From: Charlotte Grant [REDACTED]
Sent: 14 March 2019 17:28
To: Simon Davis [REDACTED]
Cc: Daniel Stroud [REDACTED]
Subject: Re: BR/270/18/PL - 18-20 London Road, Bognor Regis, PO21 1PY
Importance: High

Re BR/270/18/PL – “Part conversion & extension of existing building to provide 6 No. additional storeys over existing rooftop to provide up to 104 No. student residential units with access from Bedford Street, associated servicing & ancillary accommodation, entrance & new internal stairs to existing building to provide access from Bedford Street.”

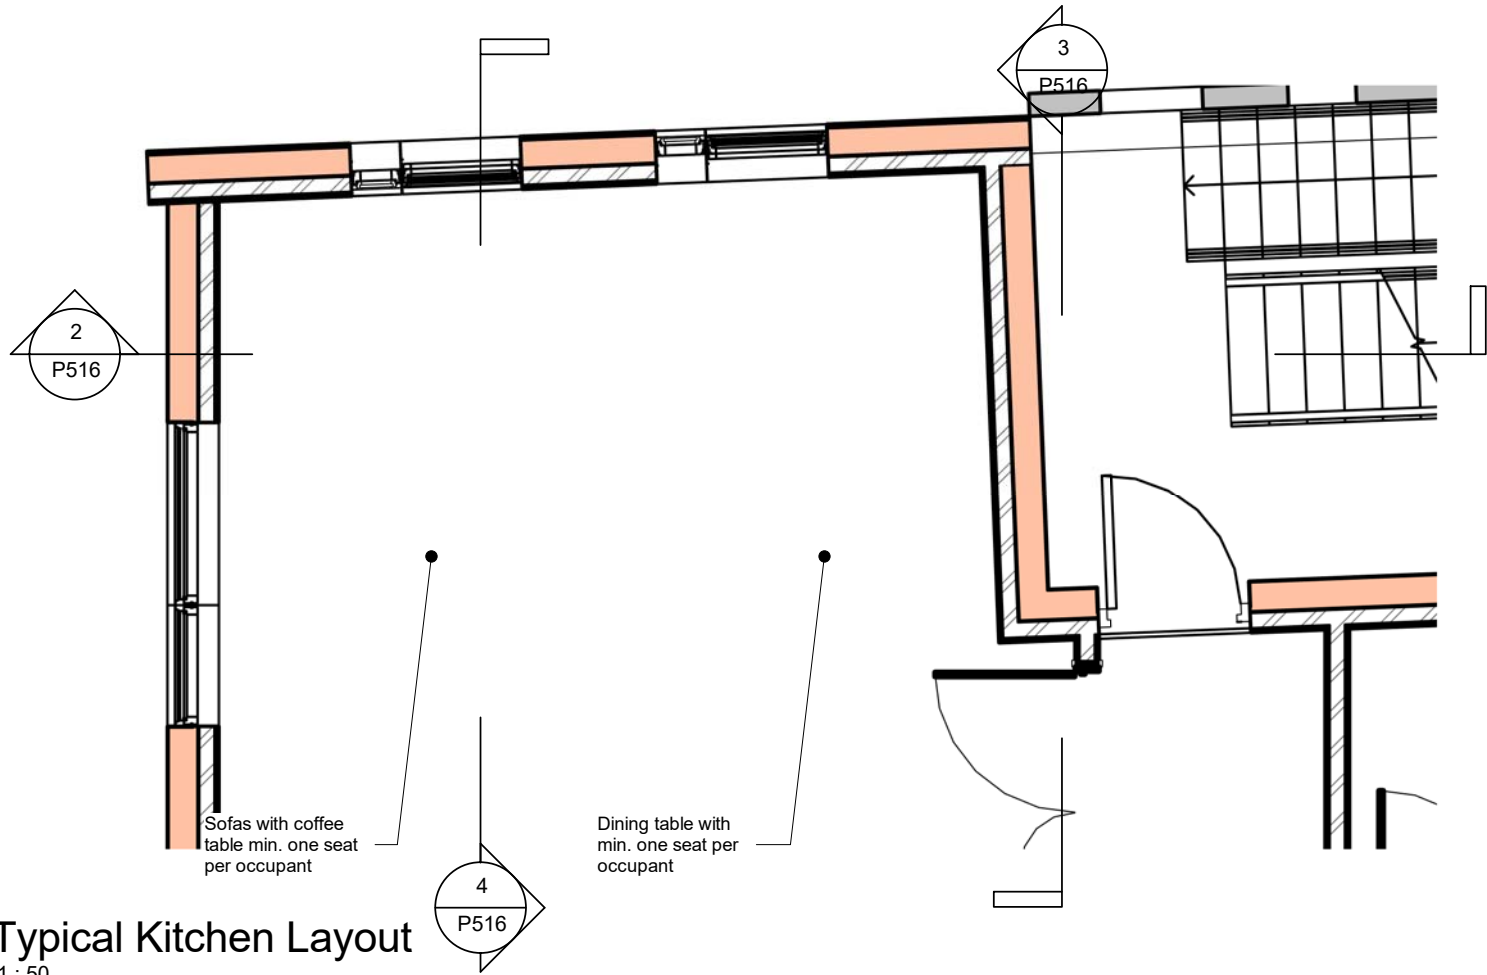
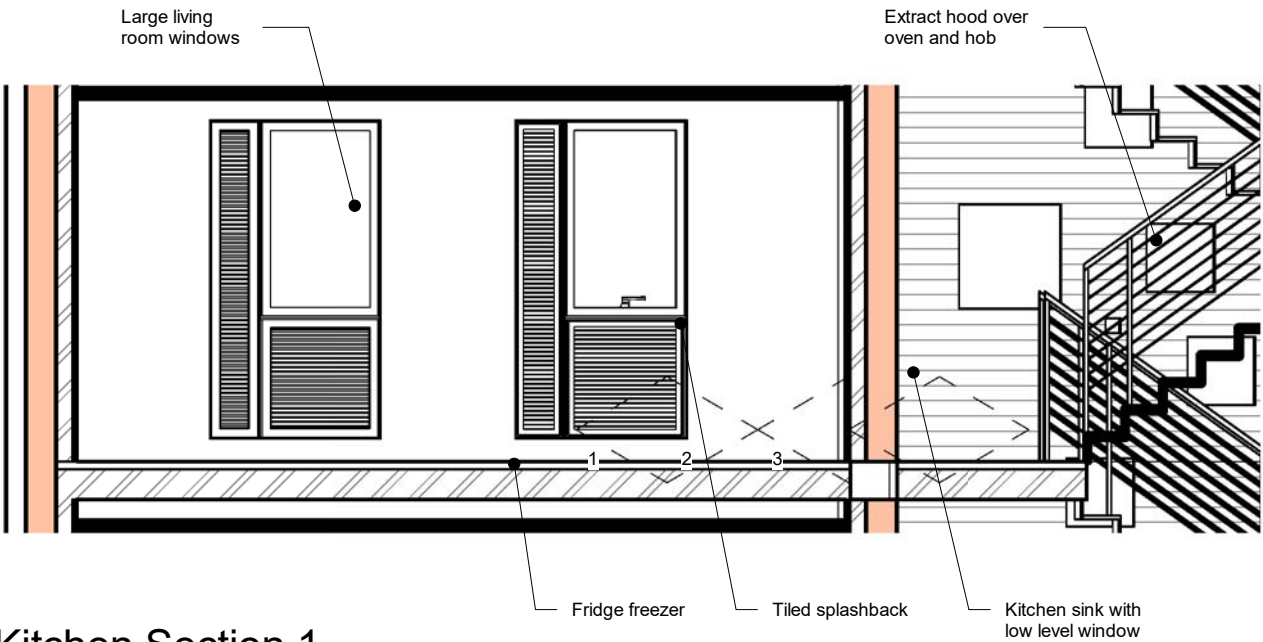
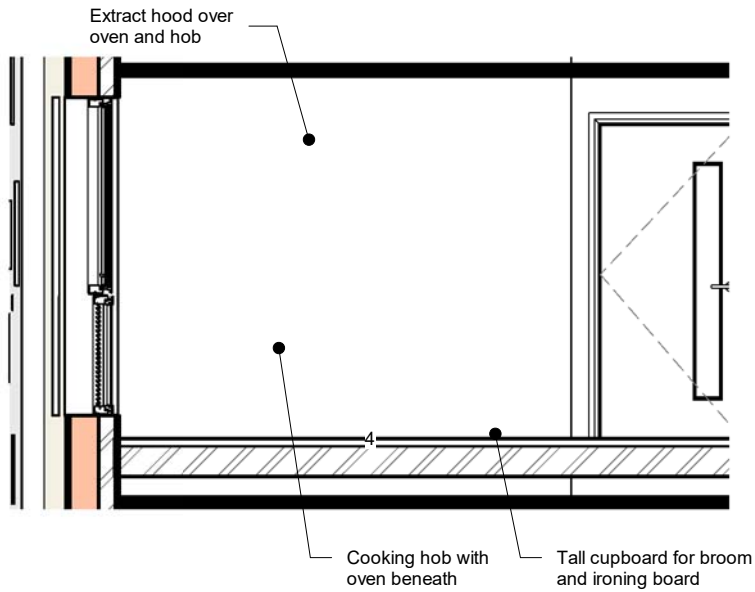
- Room sizes should meet the minimum standards for houses in multiple occupation as the flats are intended to be rented, these standards can be found on the Council's website <https://www.arun.gov.uk/hmo>

- Non-ensuite rooms are generally a minimum of 11.6m^2 and ensuite bedrooms are 14.5m^2 (12.3m^2 plus ensuite).
- Kitchens: 3 person KLD = minimum 21.8m^2 (HMO = 13.5m^2); 4 person KLD = minimum 27.5m^2 (HMO = 17m^2); 5 person KLD = minimum 27.8m^2 (HMO = 18m^2); 6 person KLD = minimum 28.1m^2 (HMO = 20m^2)
